From: Simon Davis
Sent: 05 July 2019 16:53
To: Planning.Responses
Subject: FW: Application Ref. Y/4/19/RES - Land at the Former Cinders Nursery, Cinders Lane, Yapton, BN18 0JJ
Attachments: 19.14.P101 V Site Layout.pdf; 19.14.107 Services Plan 1 of 1.pdf; 19.14.107.1 Services Plan 2 of 2.pdf; 1973-TF-00-00-DR-L-1001 P09.pdf; 18209-AA4-CA.pdf; 18209-BT4.pdf; SGN Manual - V2.1 Planning Portal.pdf
Importance: High

Subject: Application Ref. Y/4/19/RES - Land at the Former Cinders Nursery, Cinders Lane, Yapton, BN18 0JJ
Importance: High

Further to your email dated 25 June 2019 below and subsequent emails that have been exchanged between my client and yourself direct, I am pleased to attach Site Layout Plan ref. 19.14.P101V, which addresses the attached consultation response dated 25 June 2019 from WSCC Highways. Specifically:

SITE LAYOUT | SERVICES PLAN (1 of 1)
DEVELOPMENT AT:
CINDERS LANE
YAPTON
BN18 0JJ
FOR
CRAYFERN HOMES LIMITED
Scale :1:300 @ A1 Date : June 2019
Drawing No : 19.14.107

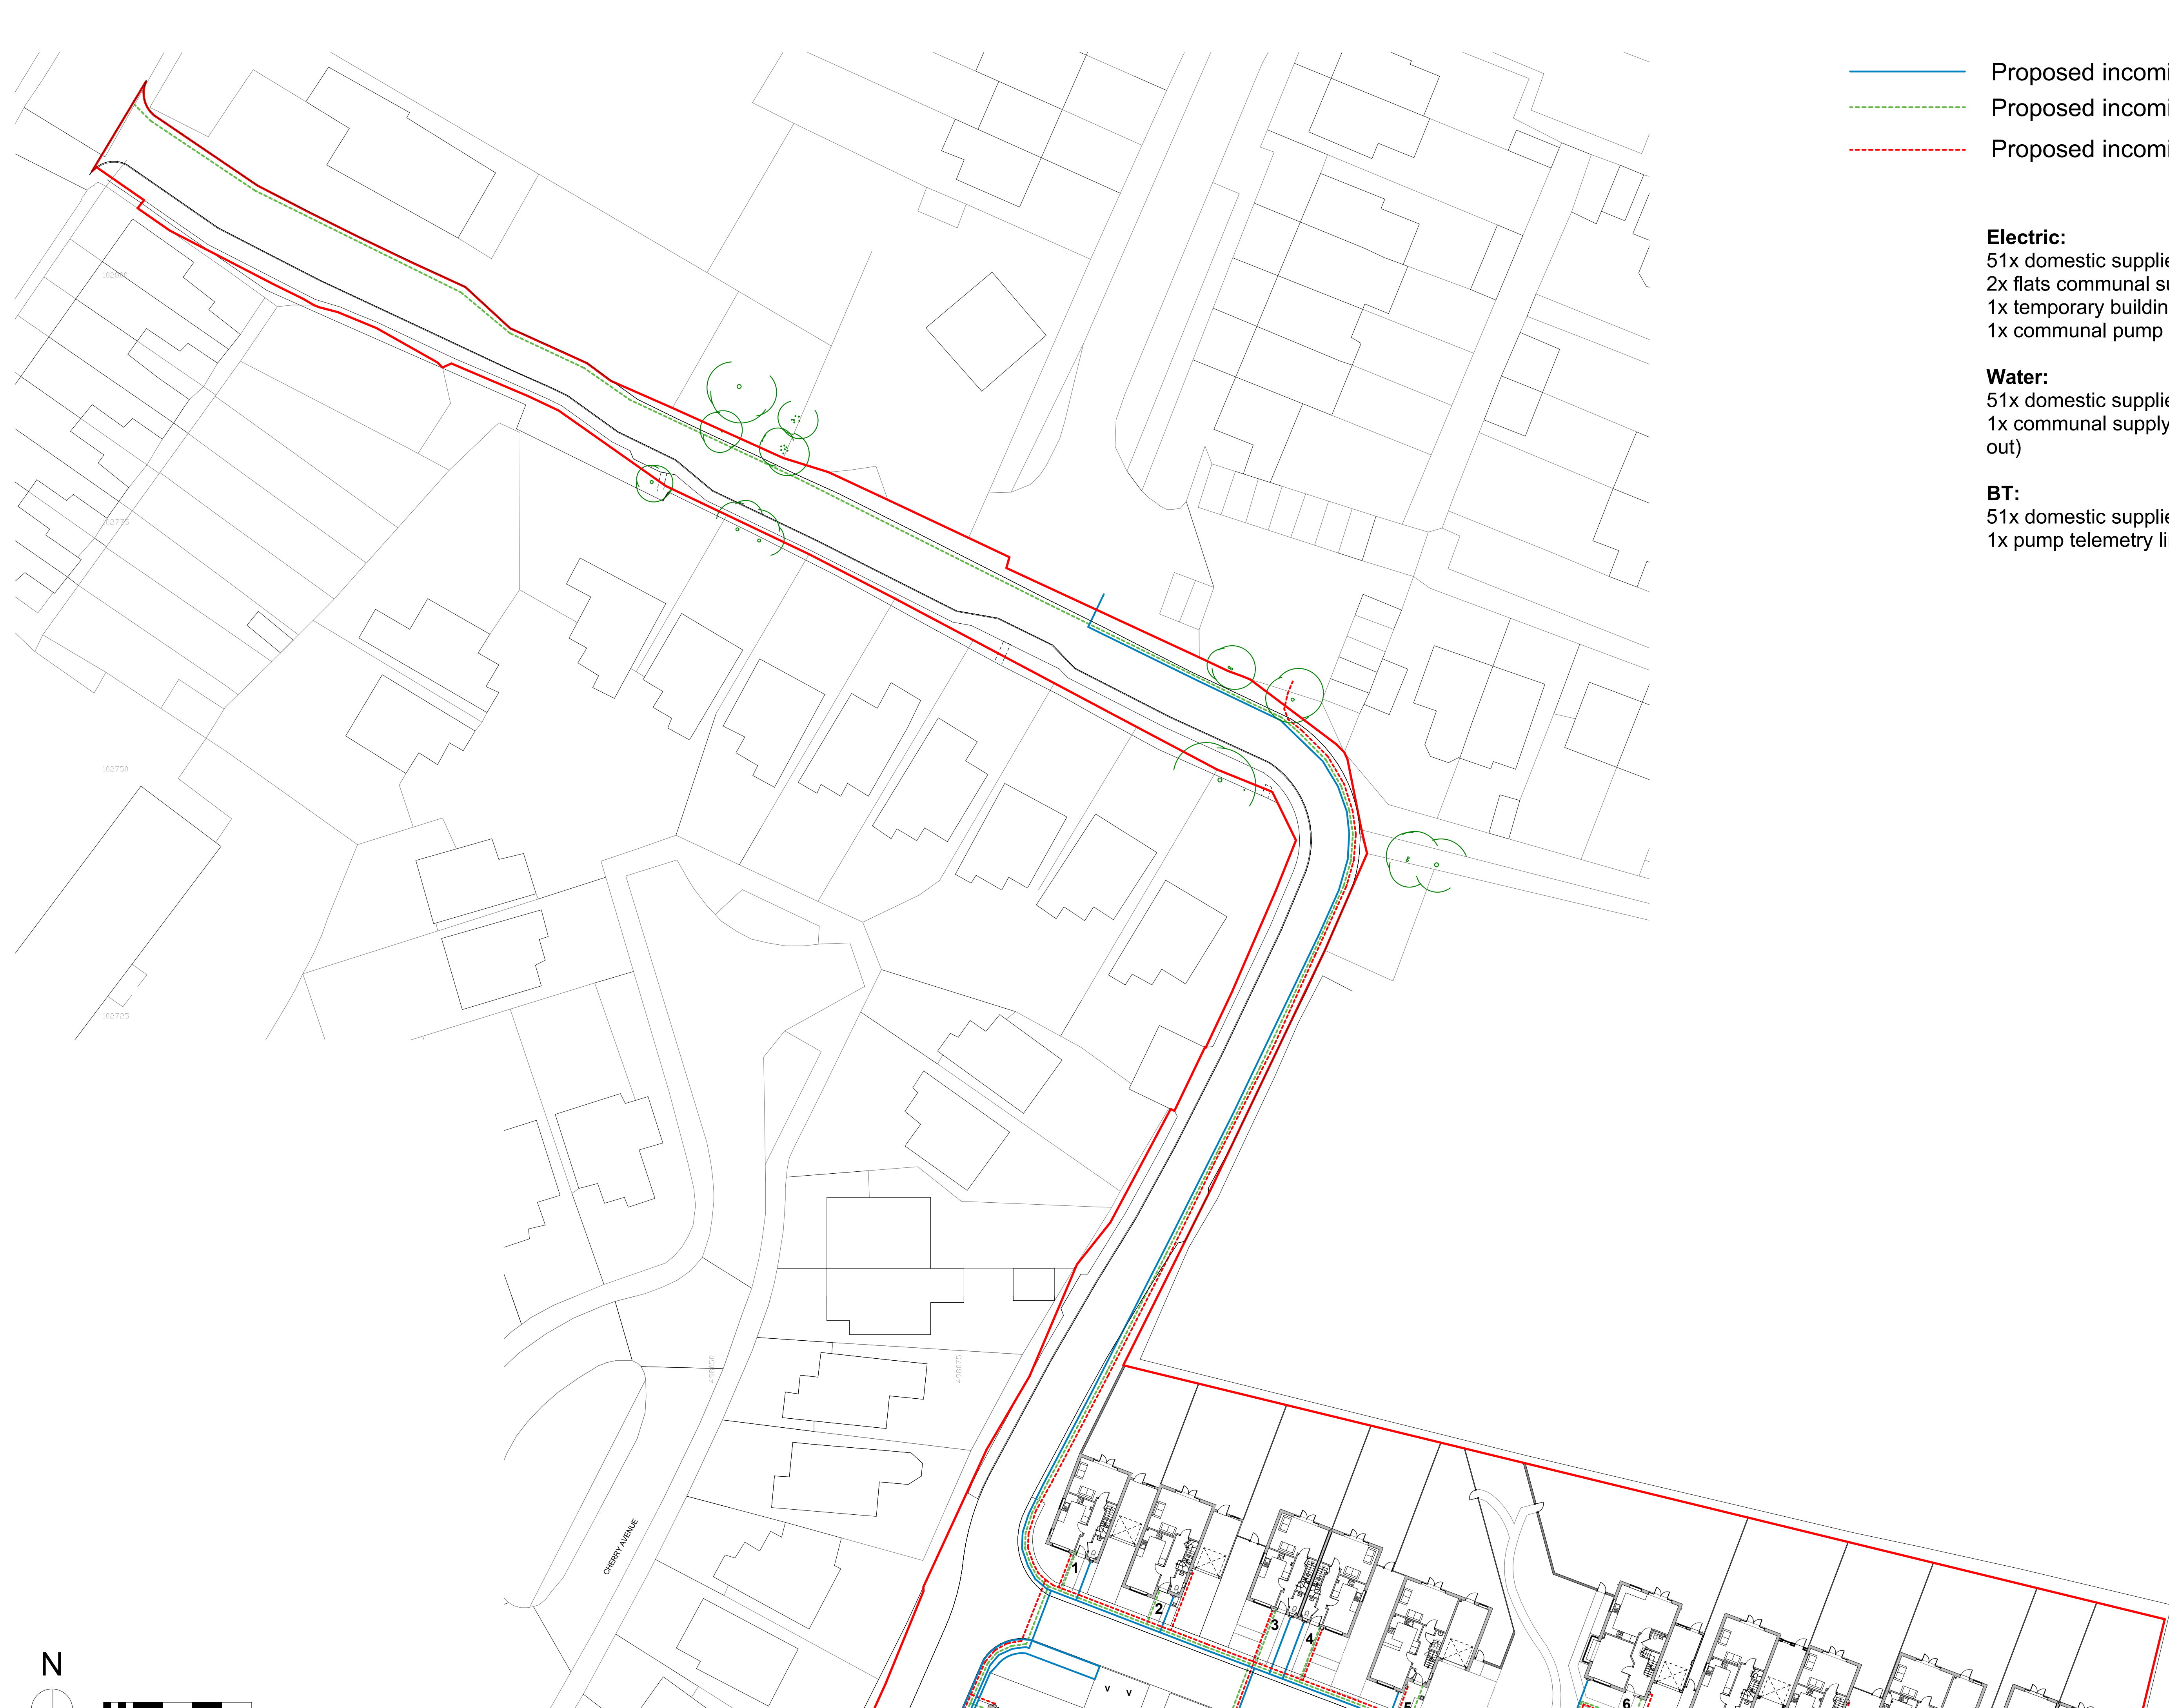
Finally, you will recall a query raised by WSCC Highways in March 2019, regarding how services would be accommodated within the site's development. Please find attached two Services Plans ref. 19.14.107 and 19.14.107.1, which indicate the position of water supply, electricity supply and telecoms runs throughout the site's development.
